City of Portland, Maine – Building or Use Permit Application 389 Congress Street, 04101, Tel: (207) 874-8703, FAX: 874-8716

BUILDING PERMIT REPORT

REASON FOR PERMIT: MAKE interior & exterior renovations

REBUILD FRONT WALL
@ 606 WASHINGTON AVE

FRONT WALL

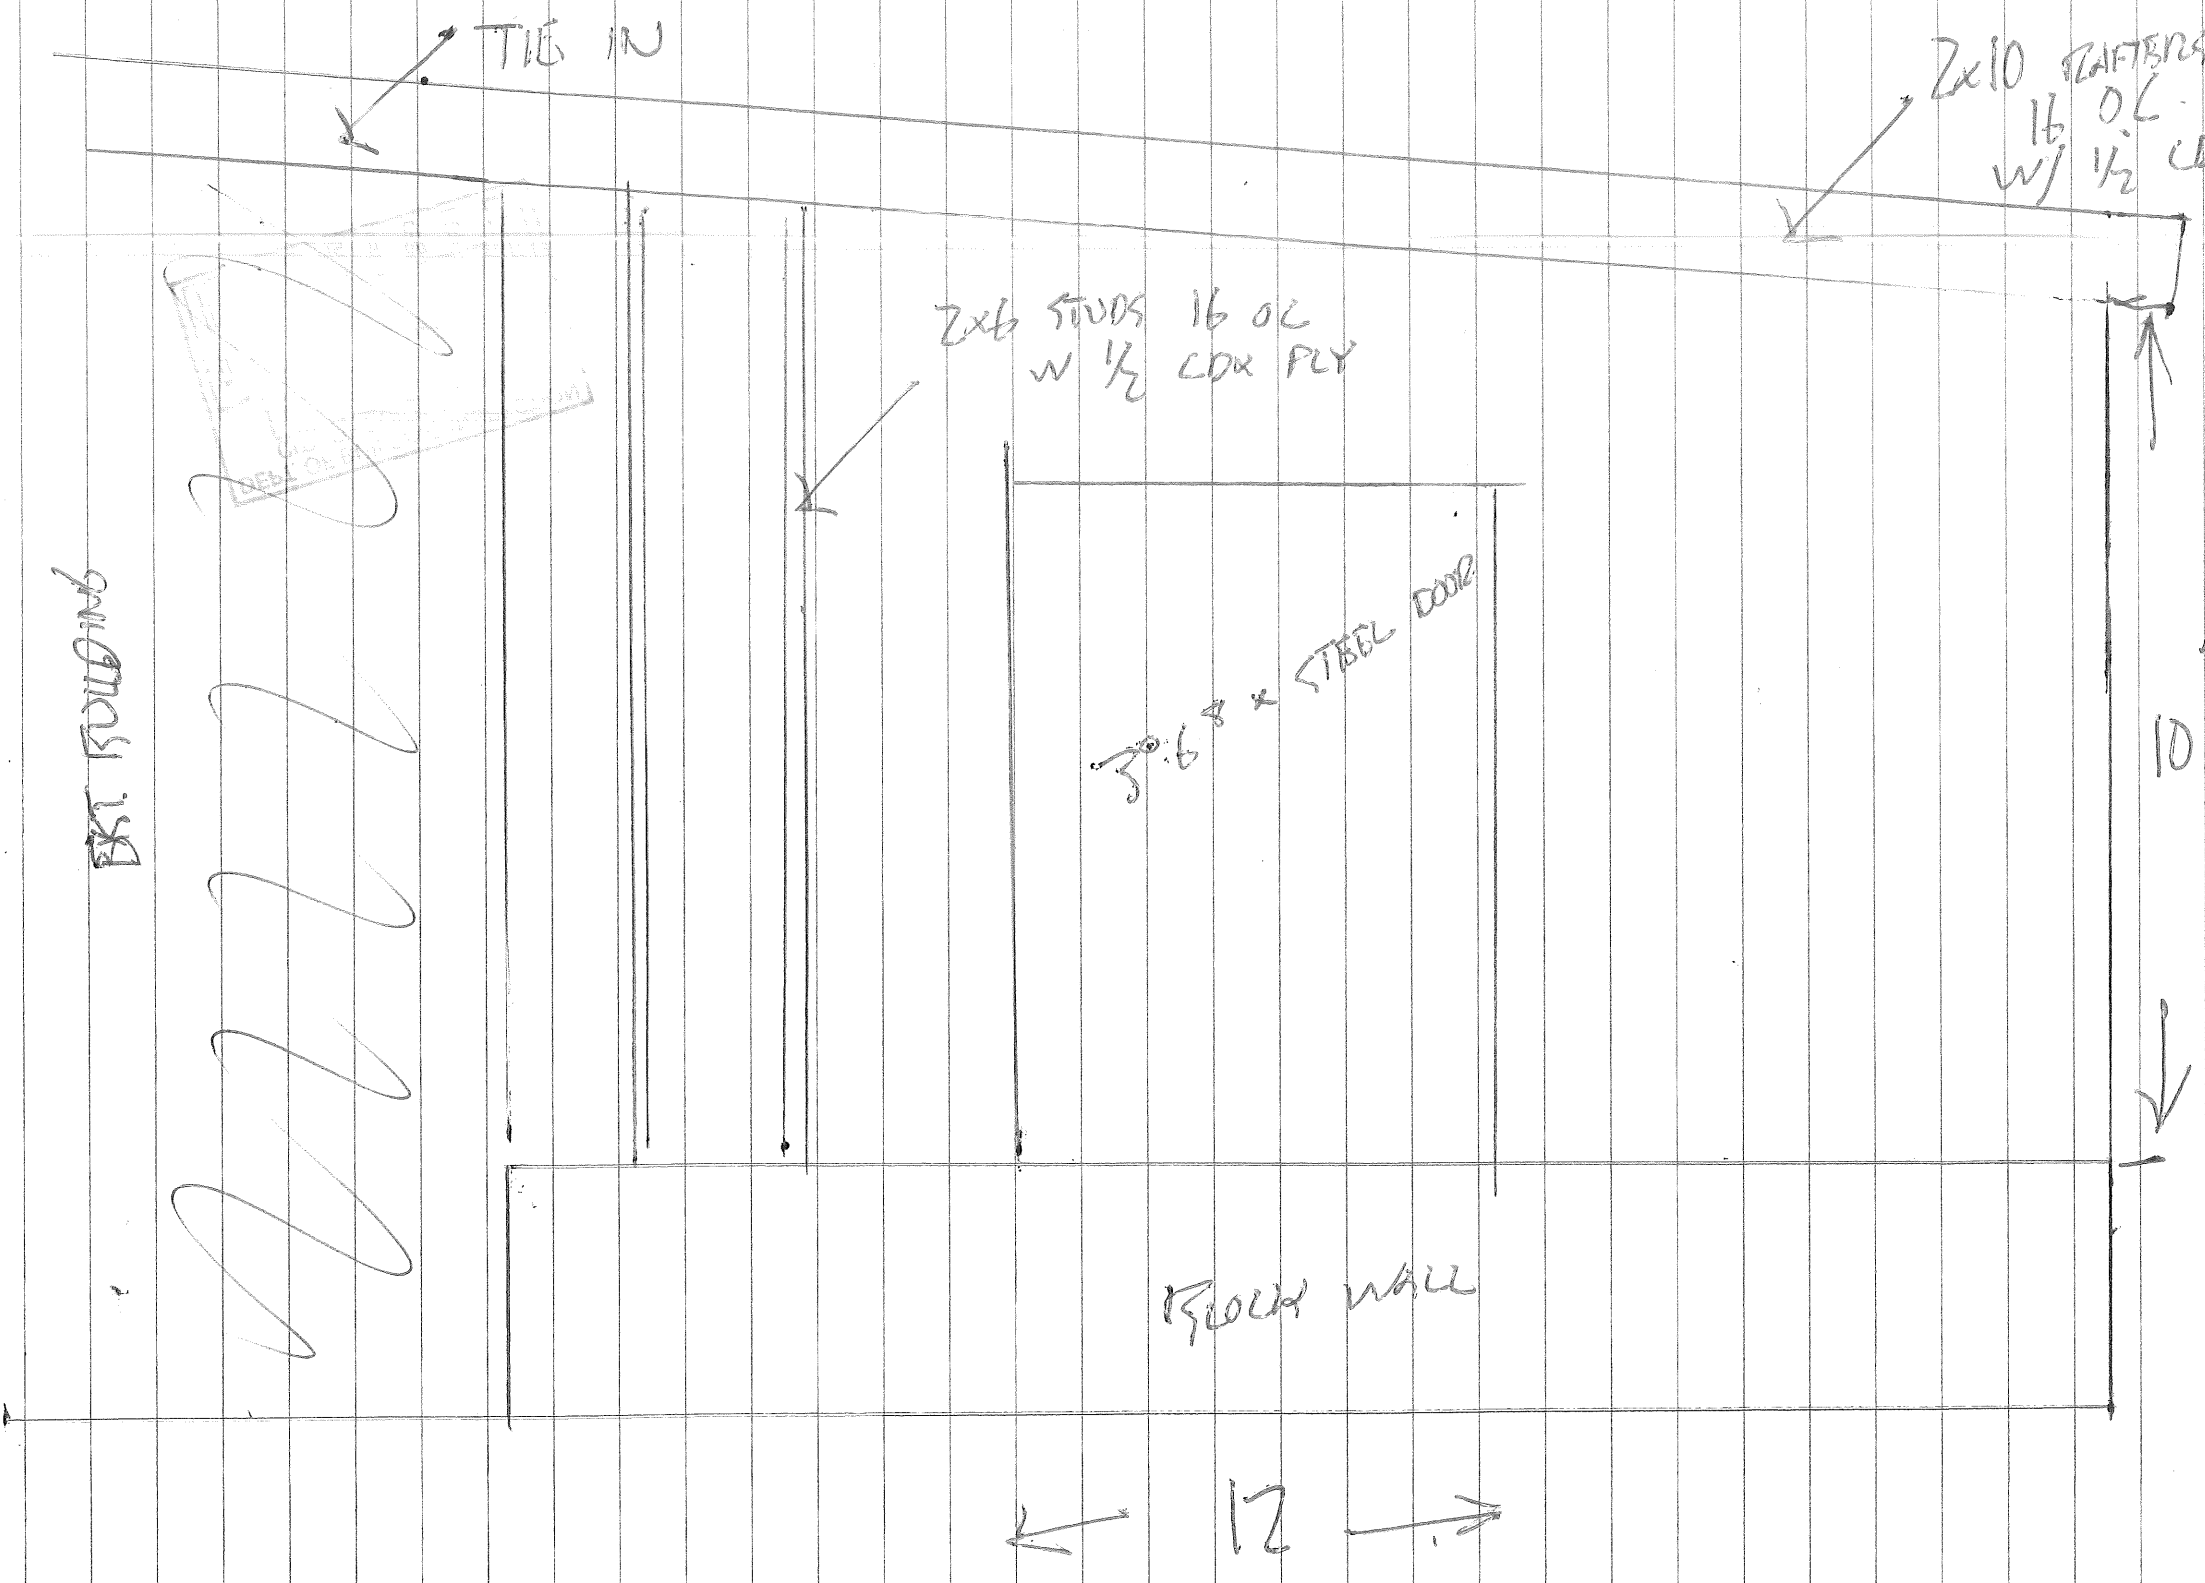
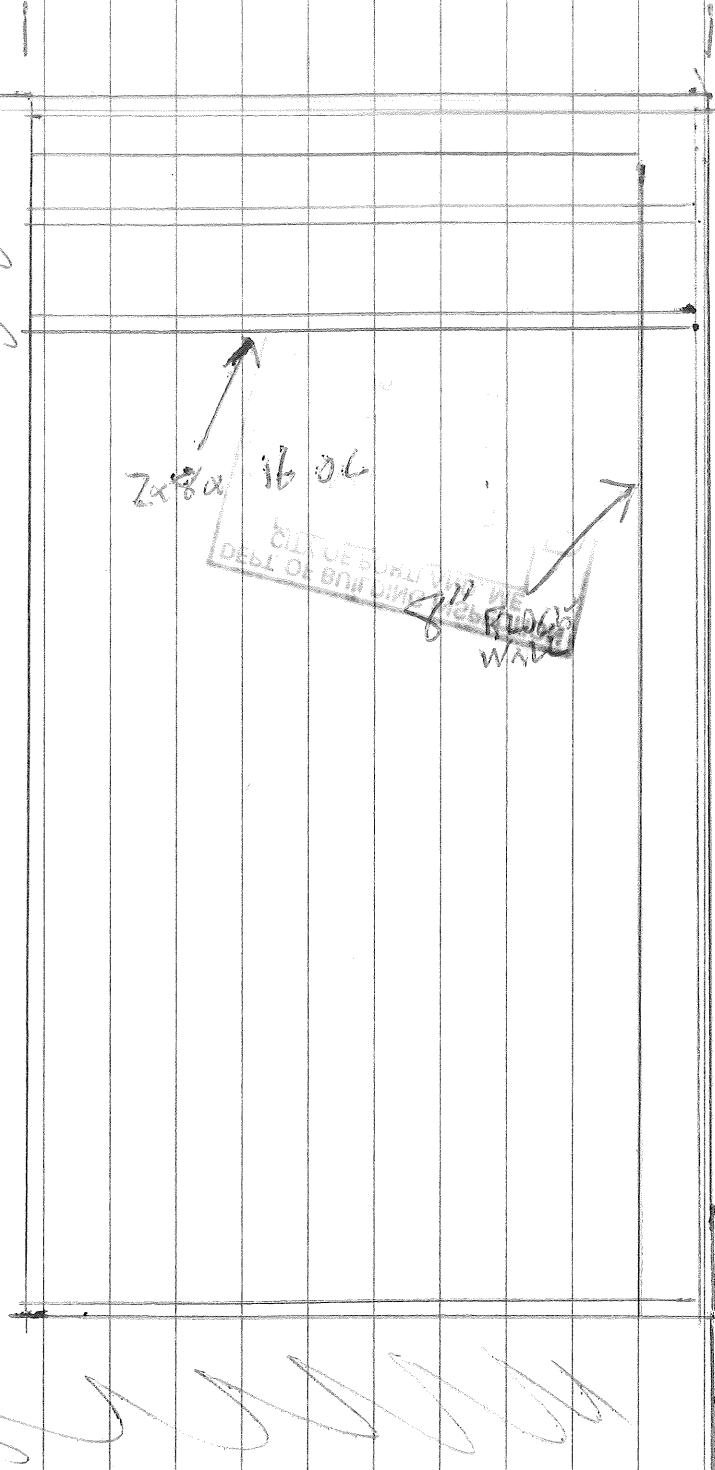
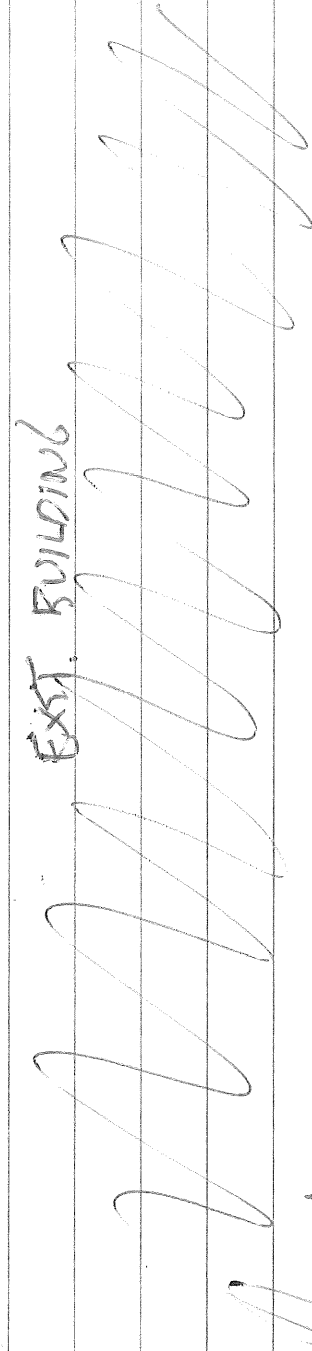
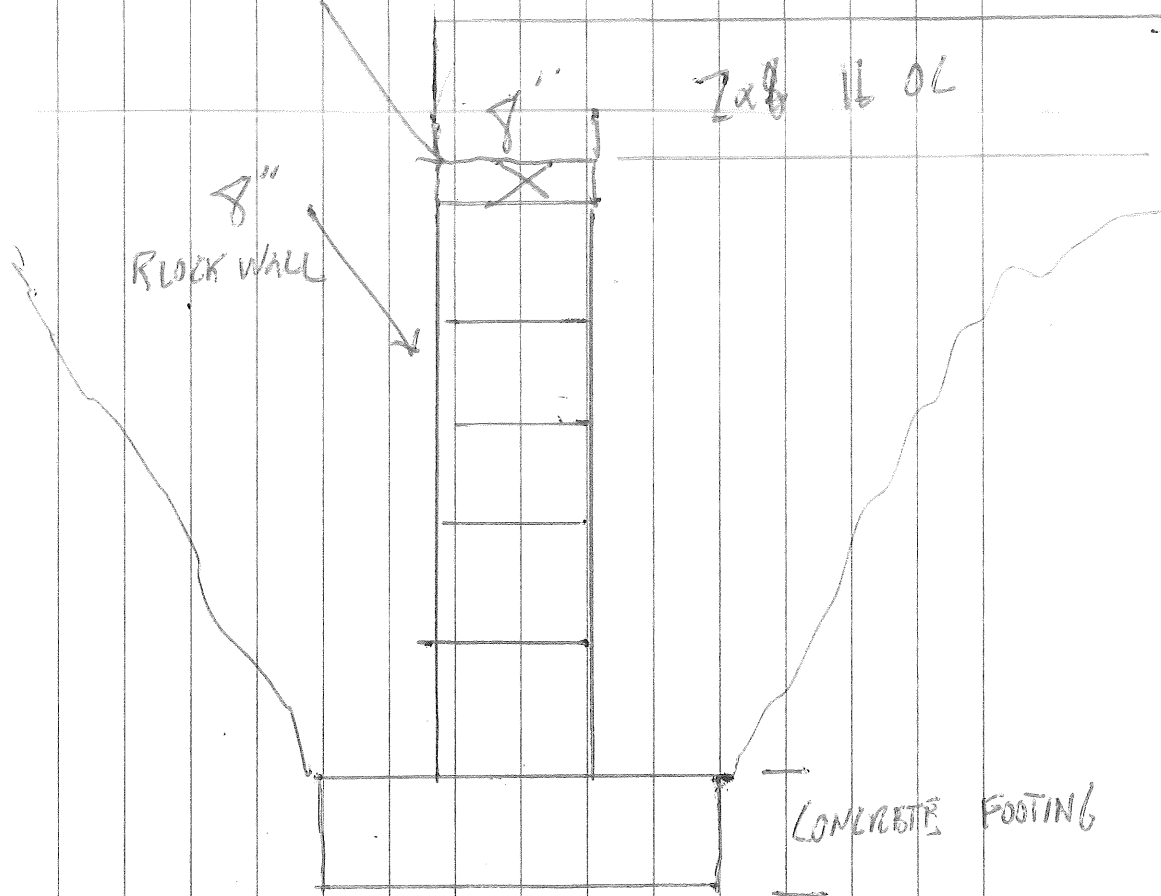
- * 25. *Your proposed plan doesn't show the header size over the windows and door - This information must be submitted for approval before work begins -*
